From: [Brenda Larsen](#)
To: [Jeff Watson](#)
Subject: RE: BL-10-00047 Baker
Date: Monday, December 13, 2010 4:17:37 PM

Re: Baker (BL-10-00047)

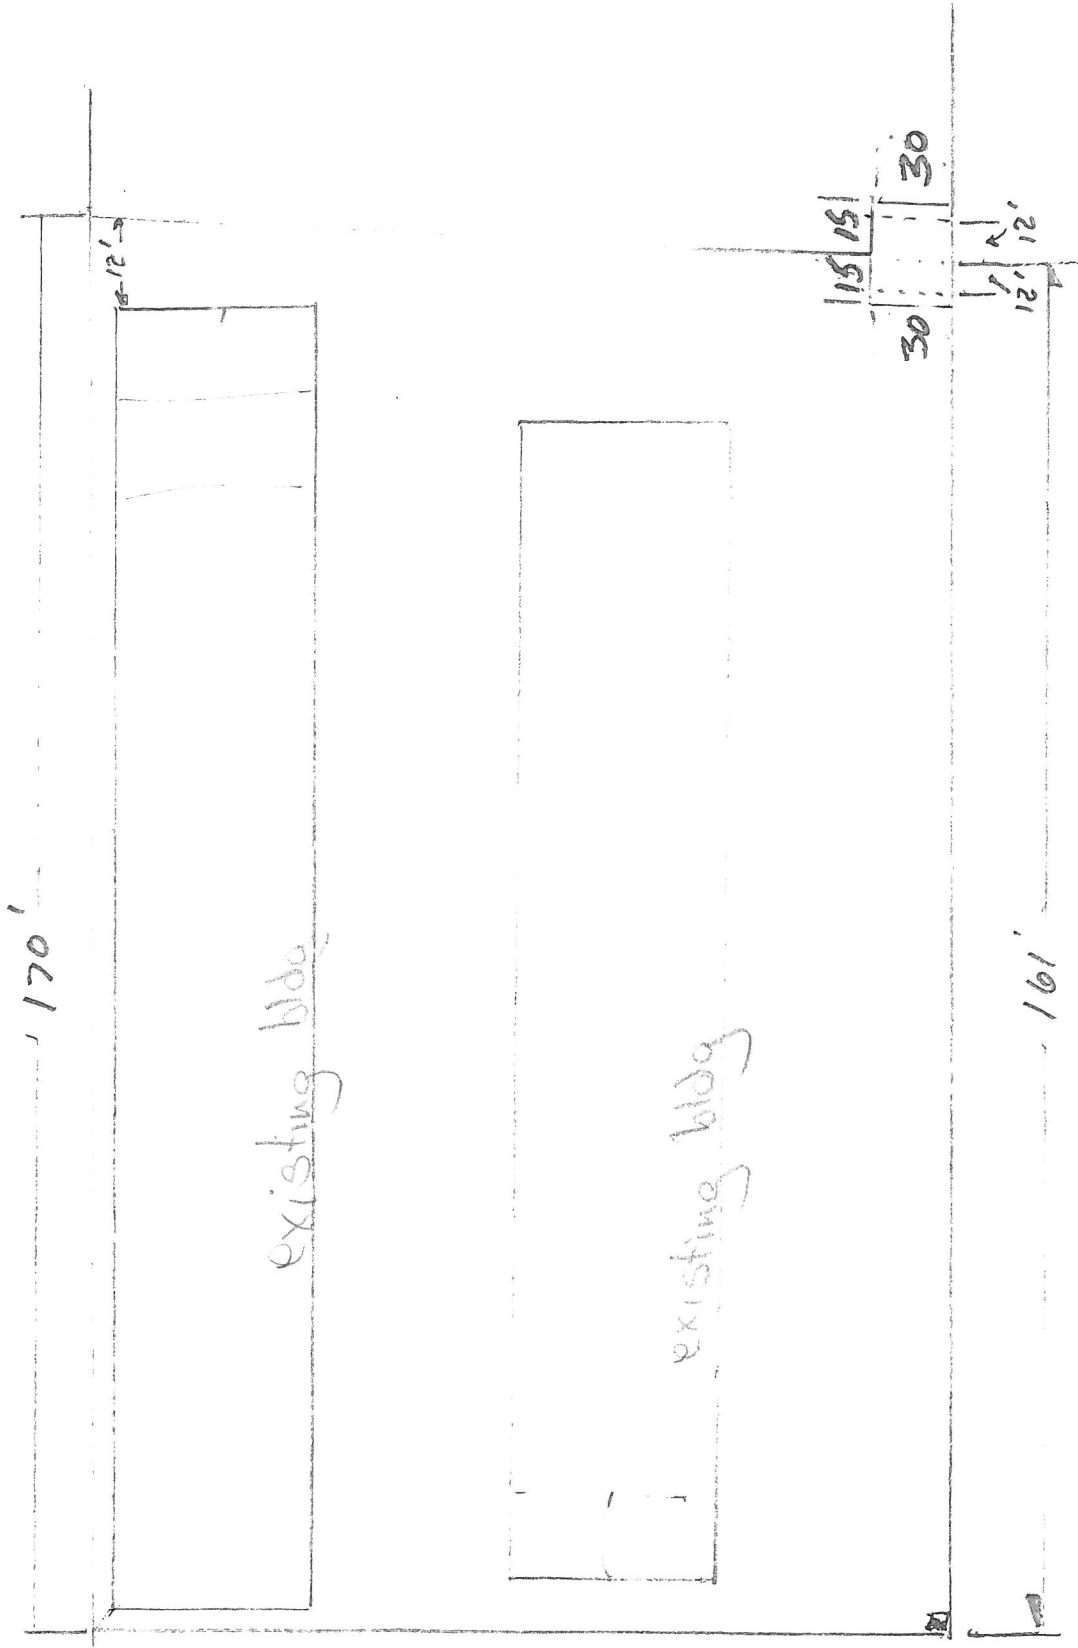
- Ensure that boundary line adjustments do not infringe upon existing structures, to include propane tanks, etc.
- Creation of any additional roads or access must comply with the International Fire Code.
- All future development must comply with the International Fire Code.
- Any future lots created off the original parent parcel will require fire flow per the International Fire Code.
